# CITY OF ALBUQUERQUE

January 8, 2007

**Re: Jaramillo-T-Mobile, Lots 19 to 21 Volcano Cliffs Unit 1, Grading Plan  
Engineer's Stamp dated 6-30-06 (E10/D22)**

SHEET: **G1**

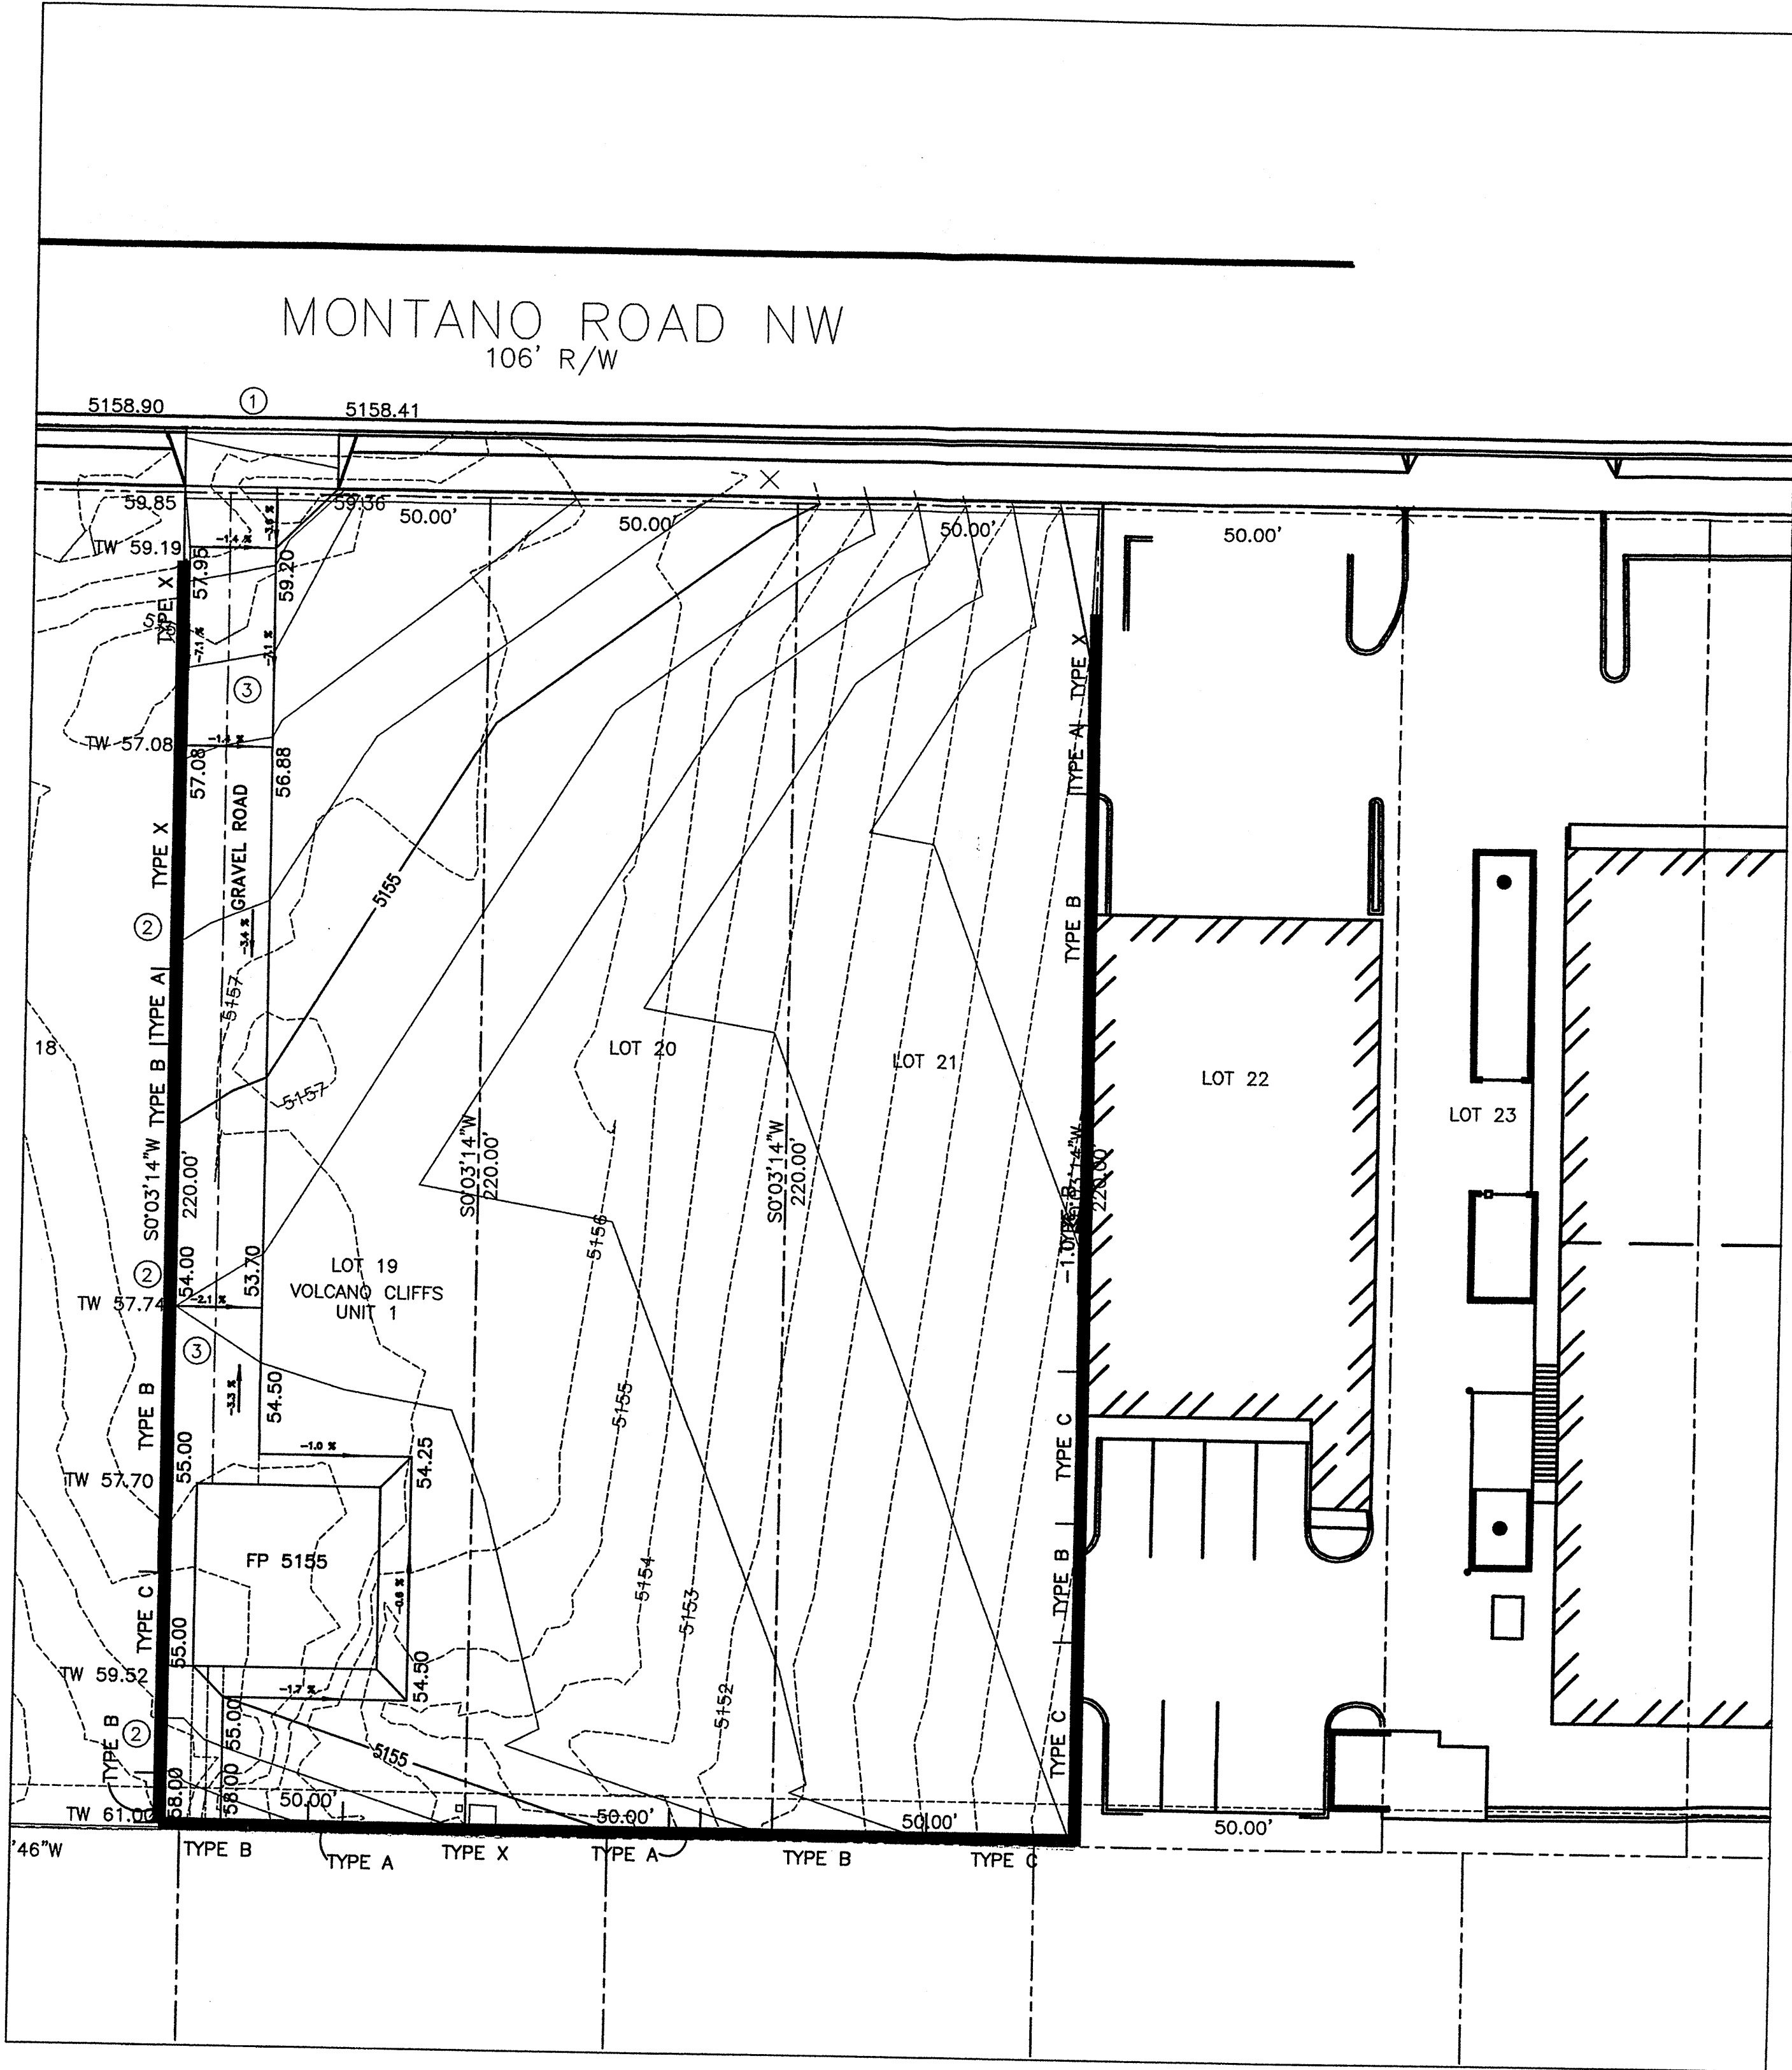
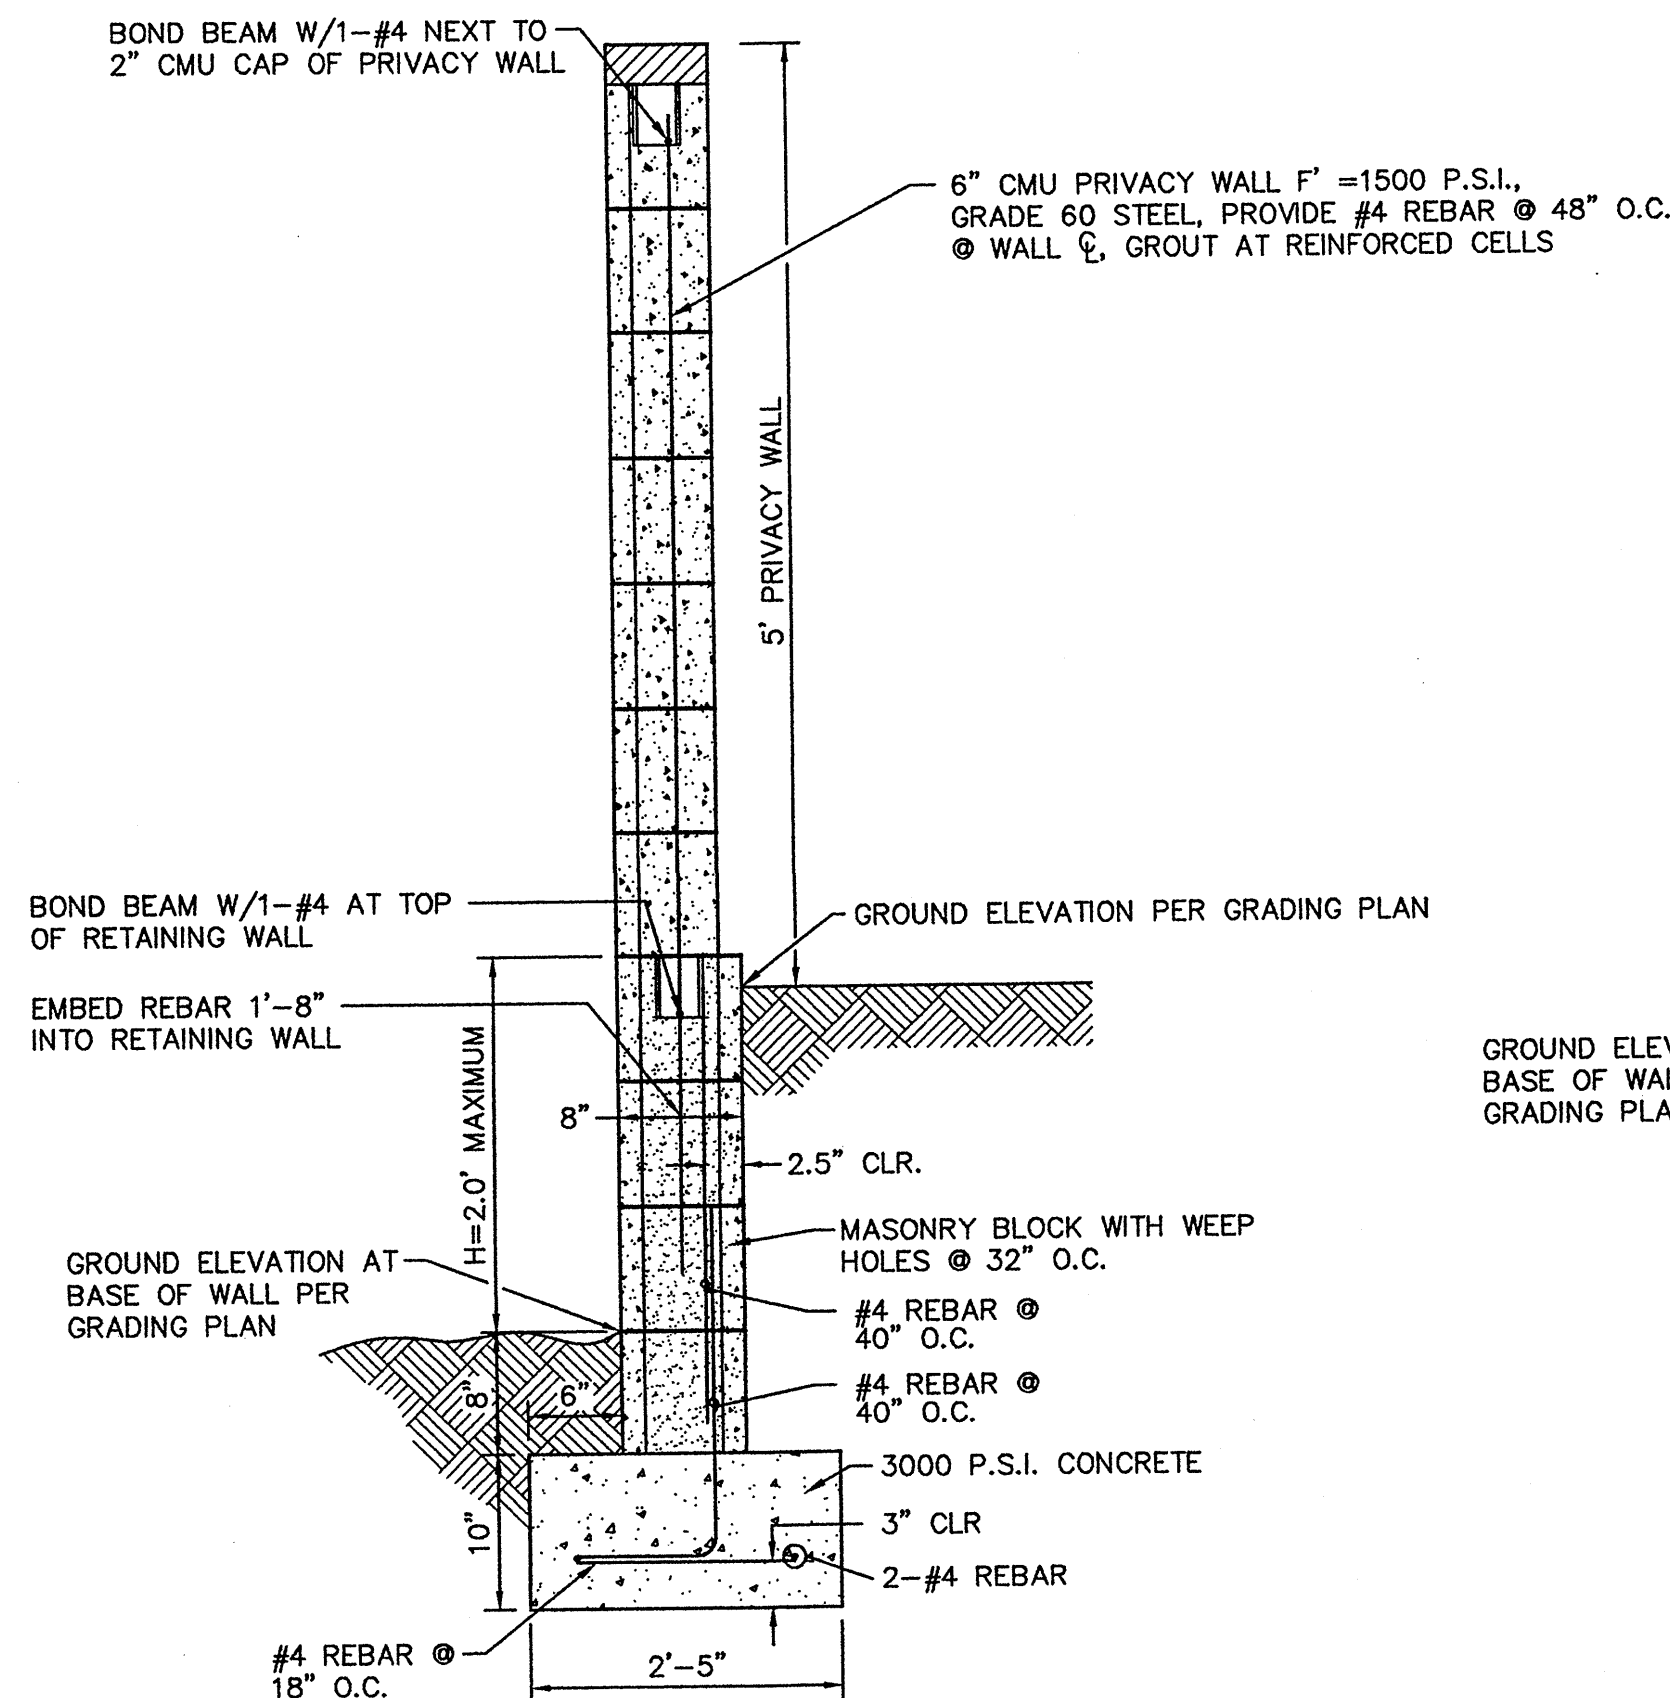
- A vicinity map is required on the plan. One of the uses of the vicinity map is to track projects. This project could not be logged into our system.
